R/285/19/HH - 17 Glenville Road Rustington (single storey rear extension)

With regard to the above project my client (in the spirit of being neighbourly) has instructed me to reduce the bulk of the extension located within the outrigger as indicated on the revised drawings 1934-03D and 1934-04D enclosed.

Scheme	REAR EXTENSION AND INTERNAL ALTERATIONS		Client	MR & MRS CAMPBELL
	TO 17 GLENVILLE ROAD, RUSTINGTON. BN16 2DU			
Title	PROPOSED ELEVATIONS.			
Scale	1:50 @ A1	Date	AUGUST 2019	Drawing Number
				1934-04D

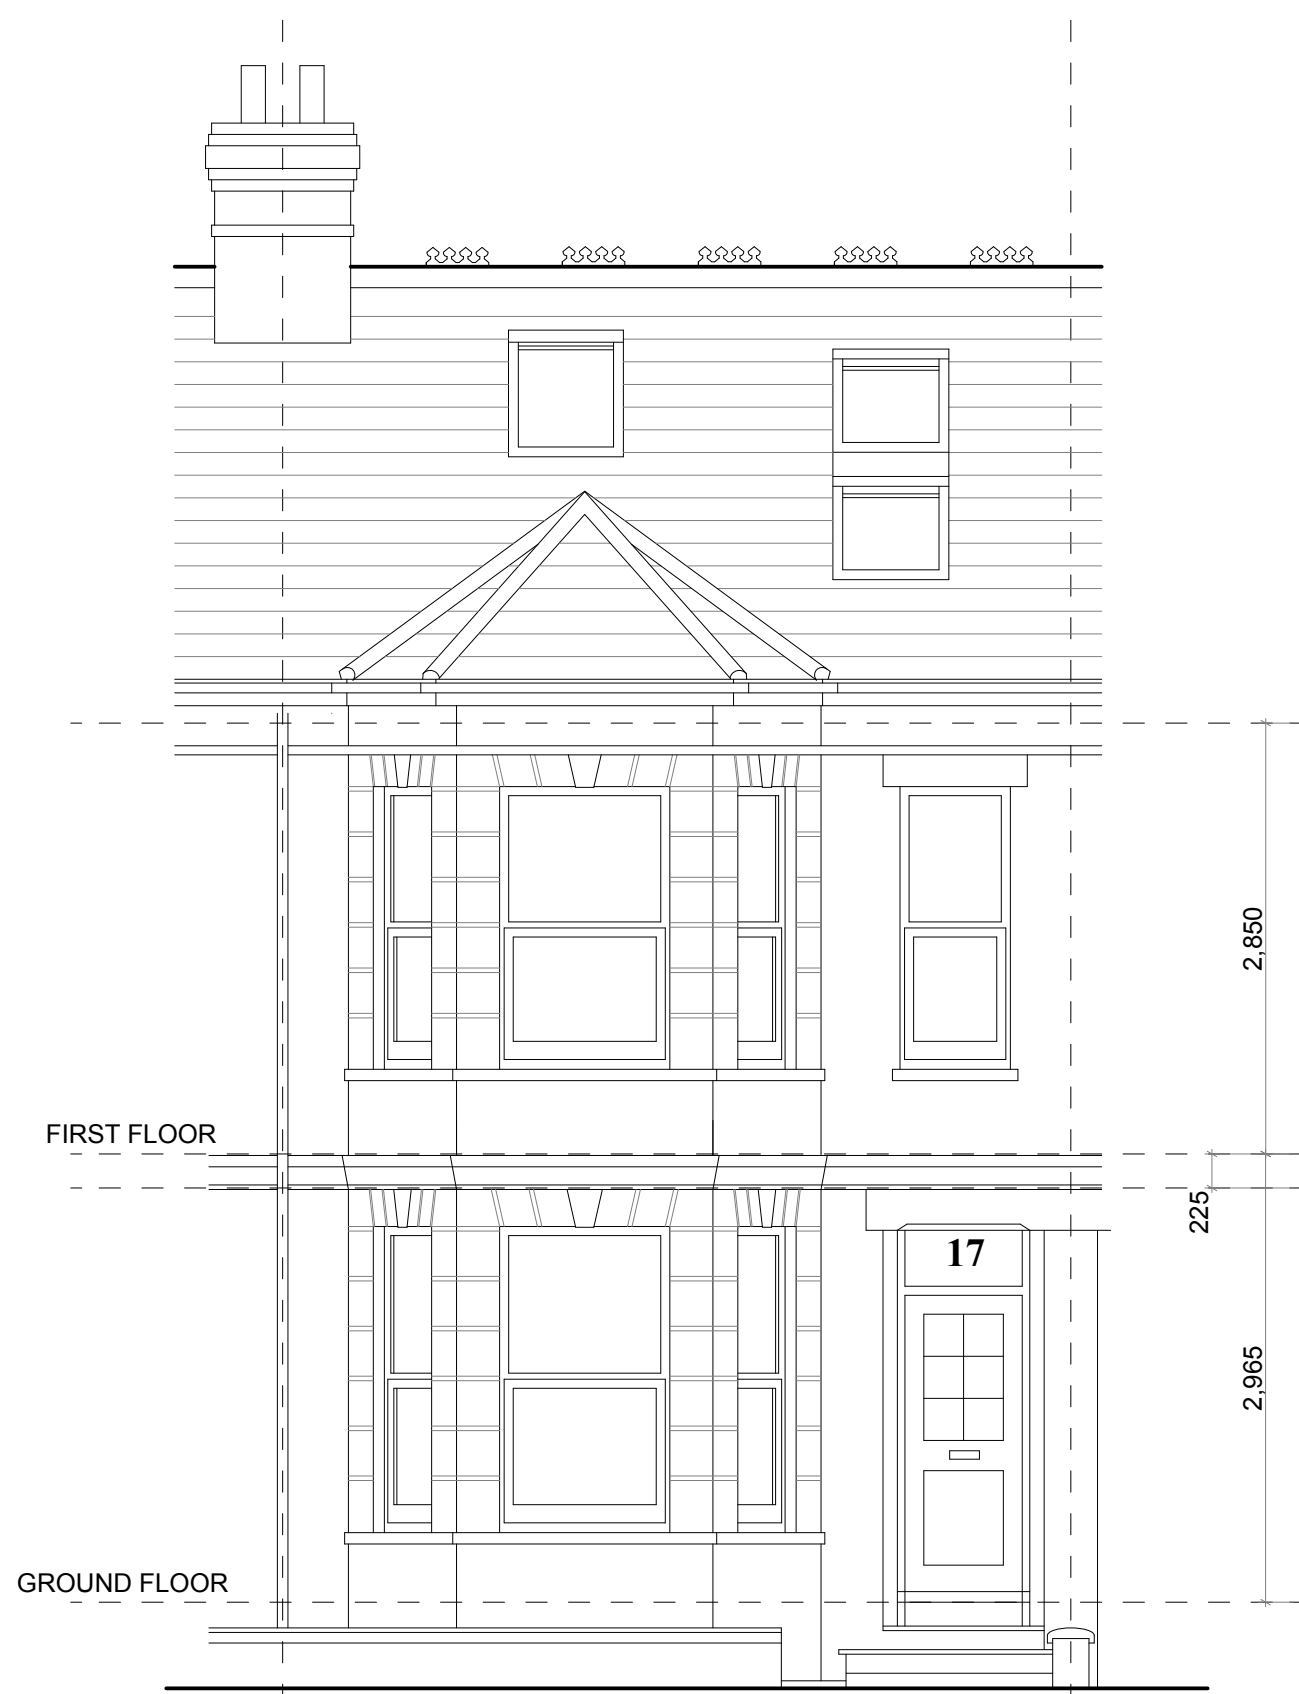
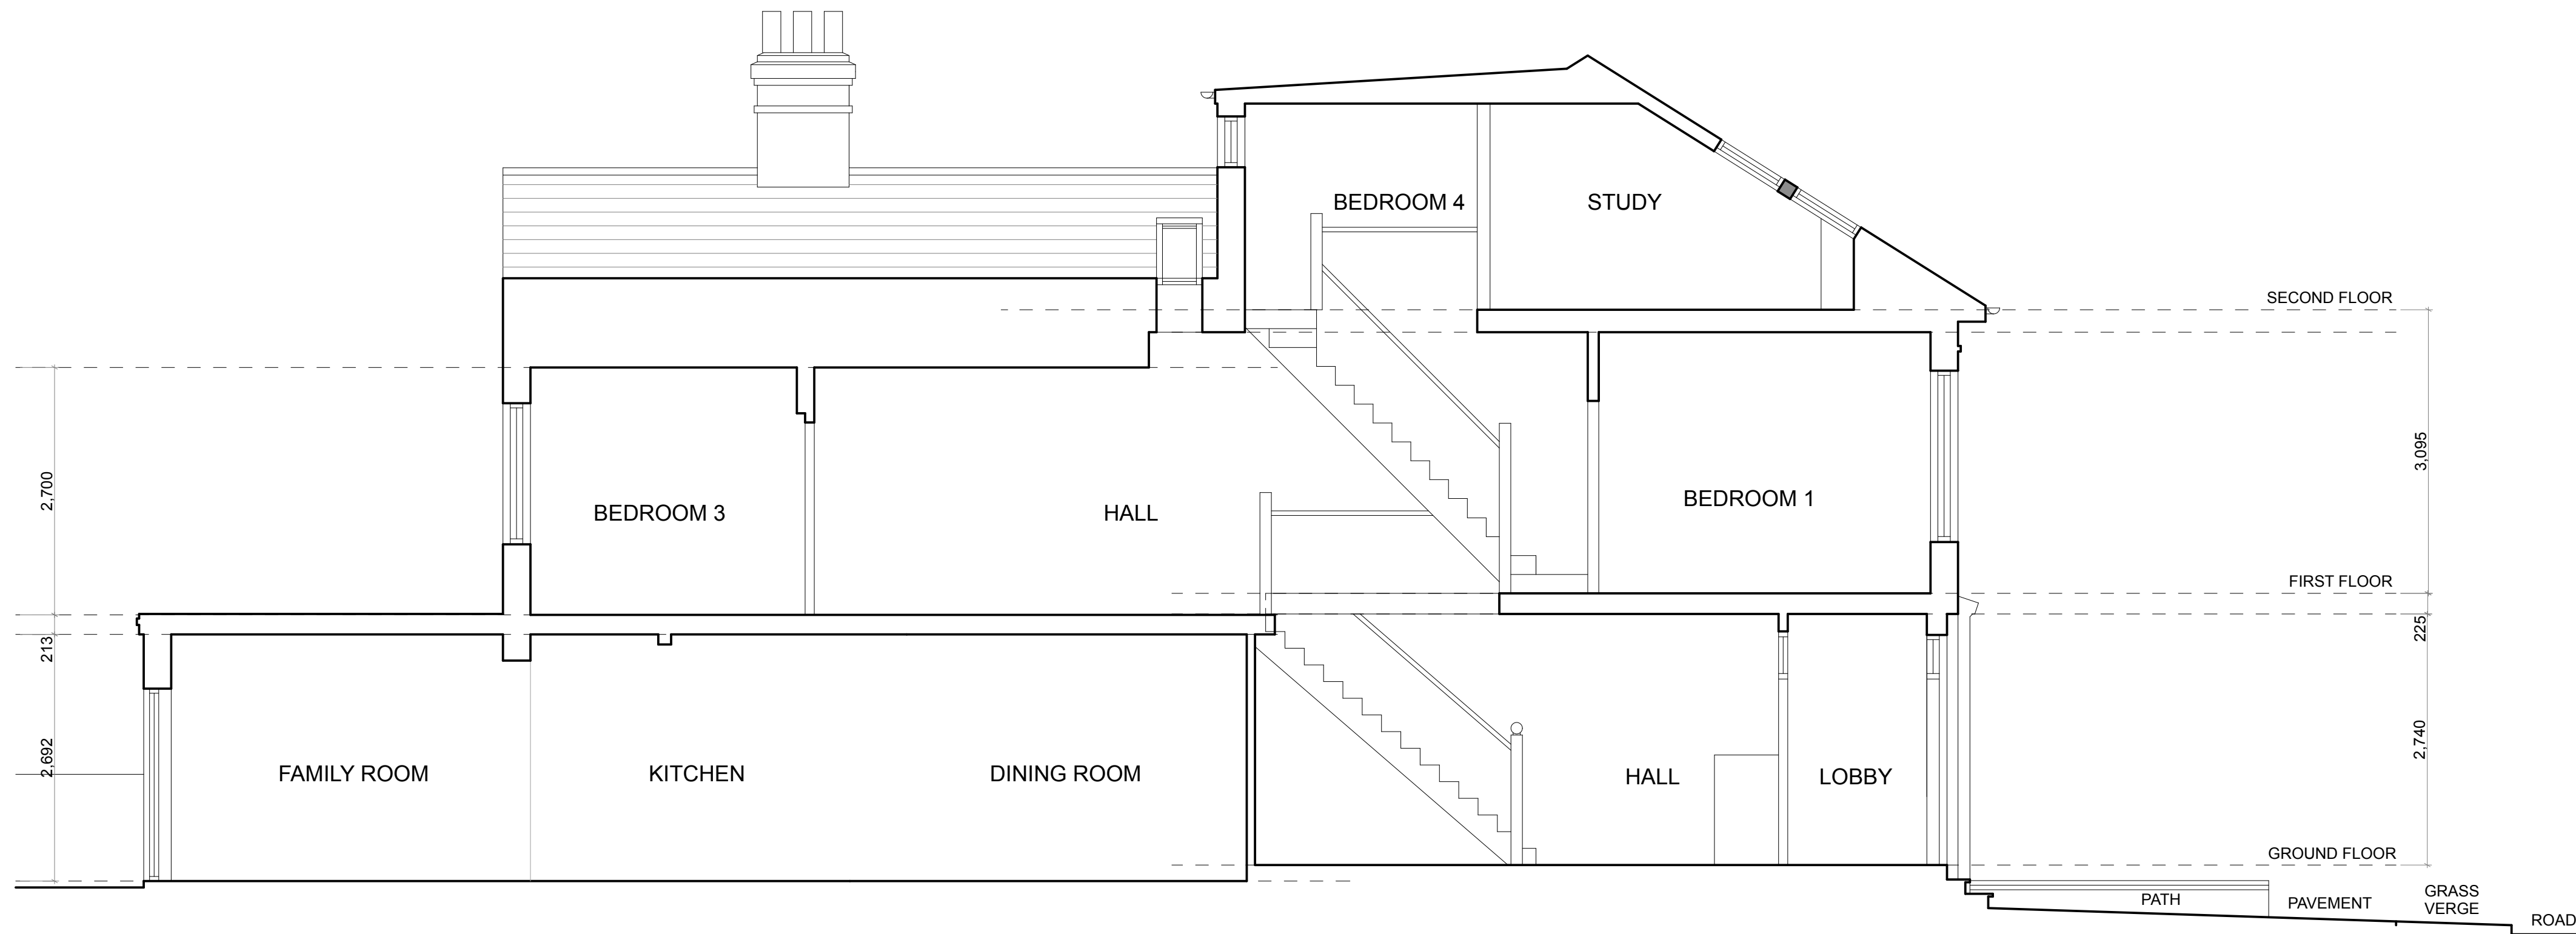
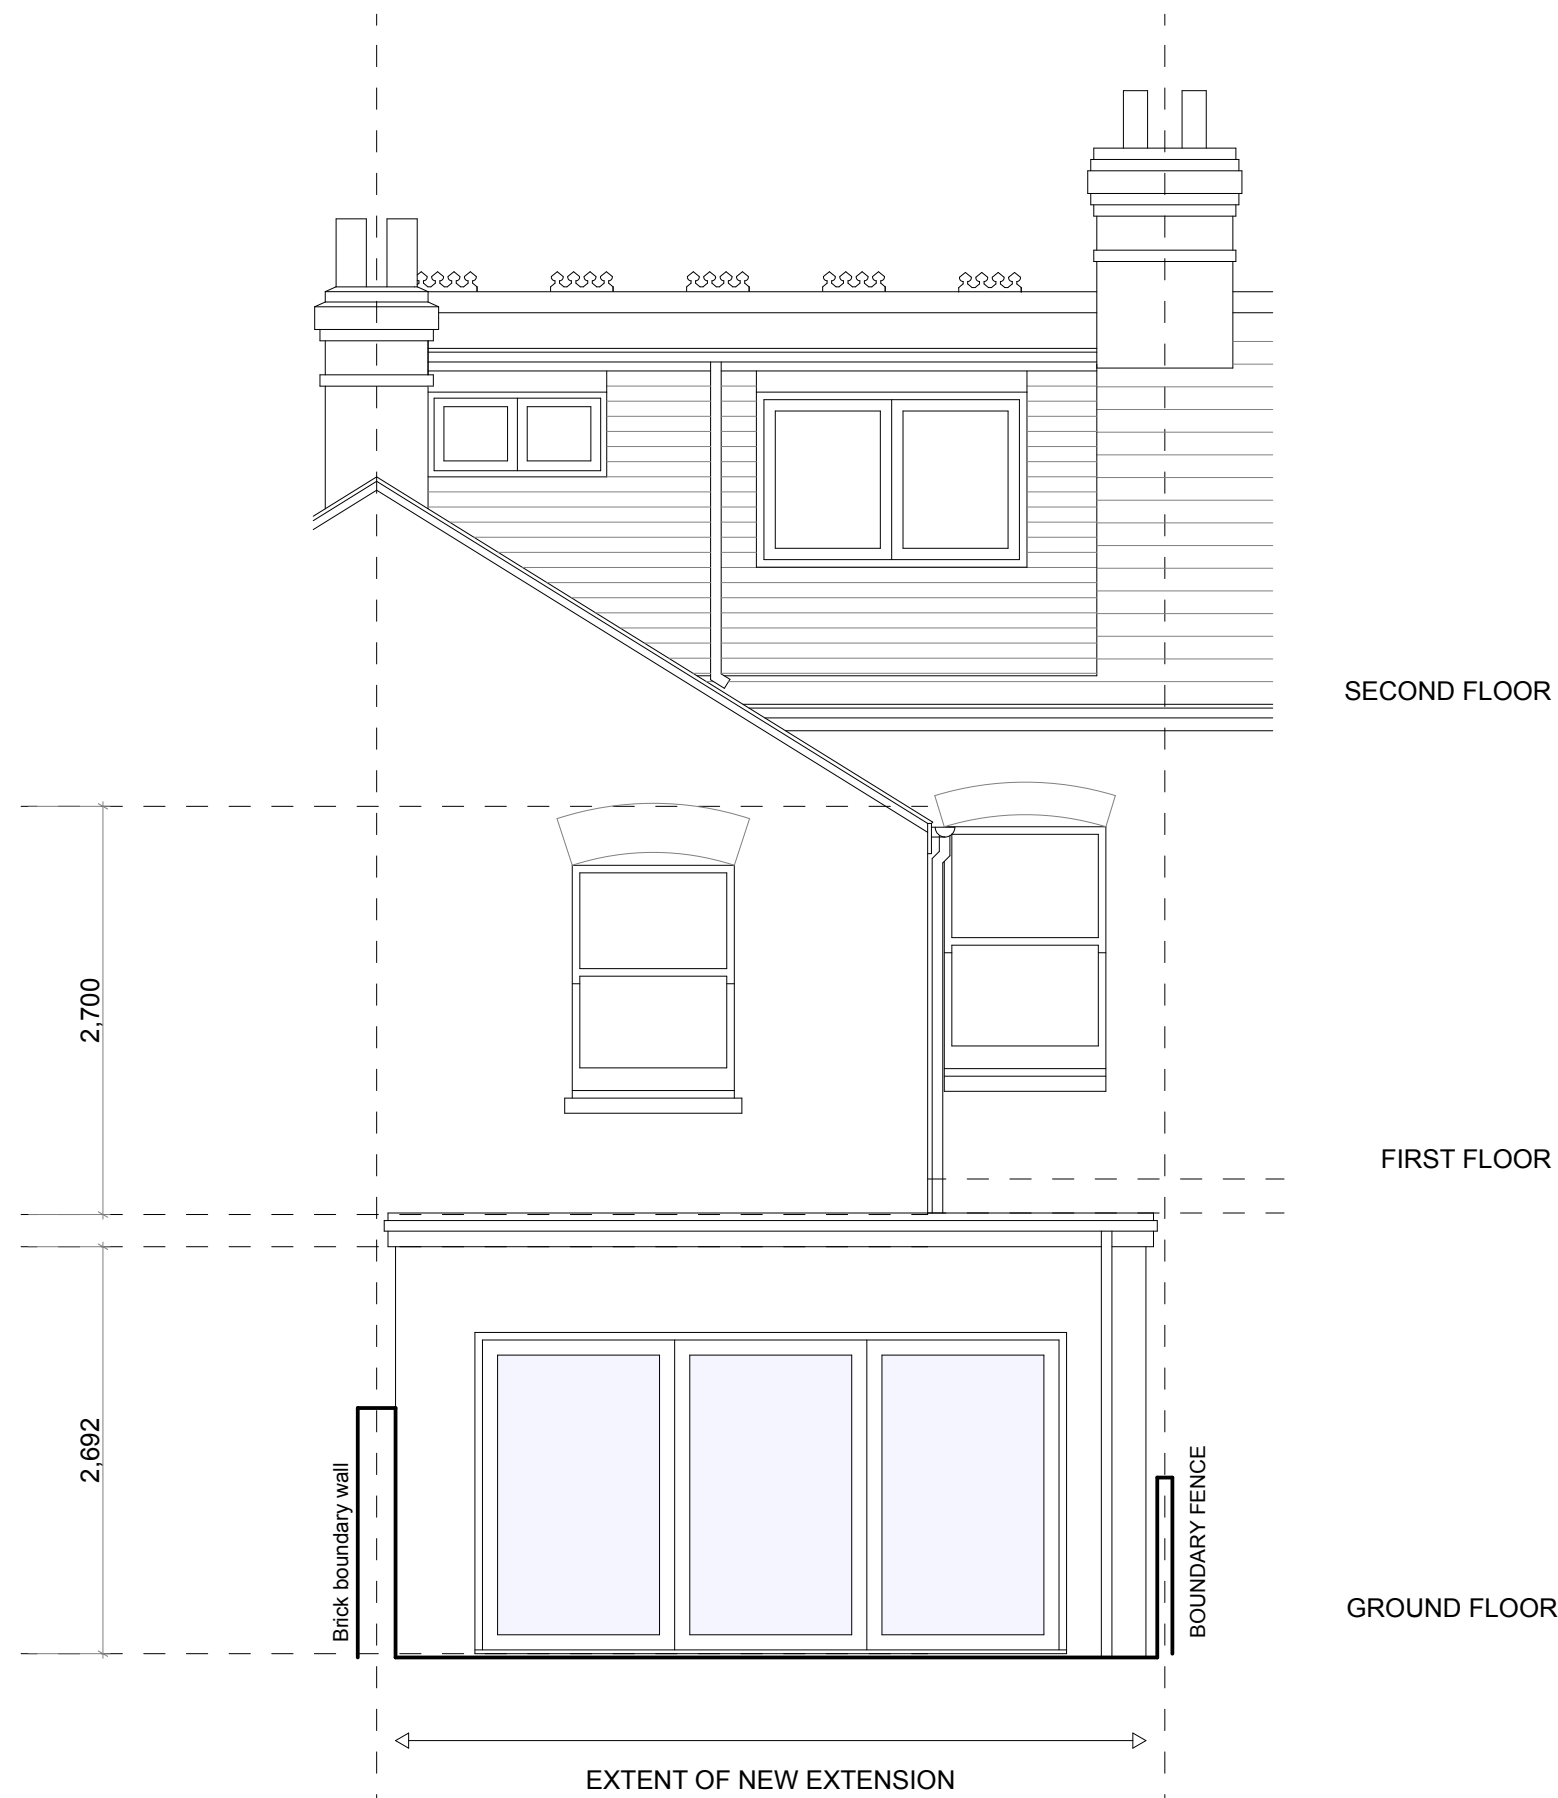
I like our neighbours and do not wish to upset the apple cart for a few extra feet. Is it possible to amend the plans so that the extension purely covers the back of the house and not down the side return?

The side door in the kitchen (leading out to the Courtyard) will remain blocked up as on the plans but both of the single windows will be re instated. Finally, could we have a fully glazed window/ door looking into/ down the Courtyard from the new extension.

Anyway – let me know your thoughts and any further comments.
Once I receive these I will also amend the elevations and block plan and formalise the revised drawings with the local authority.
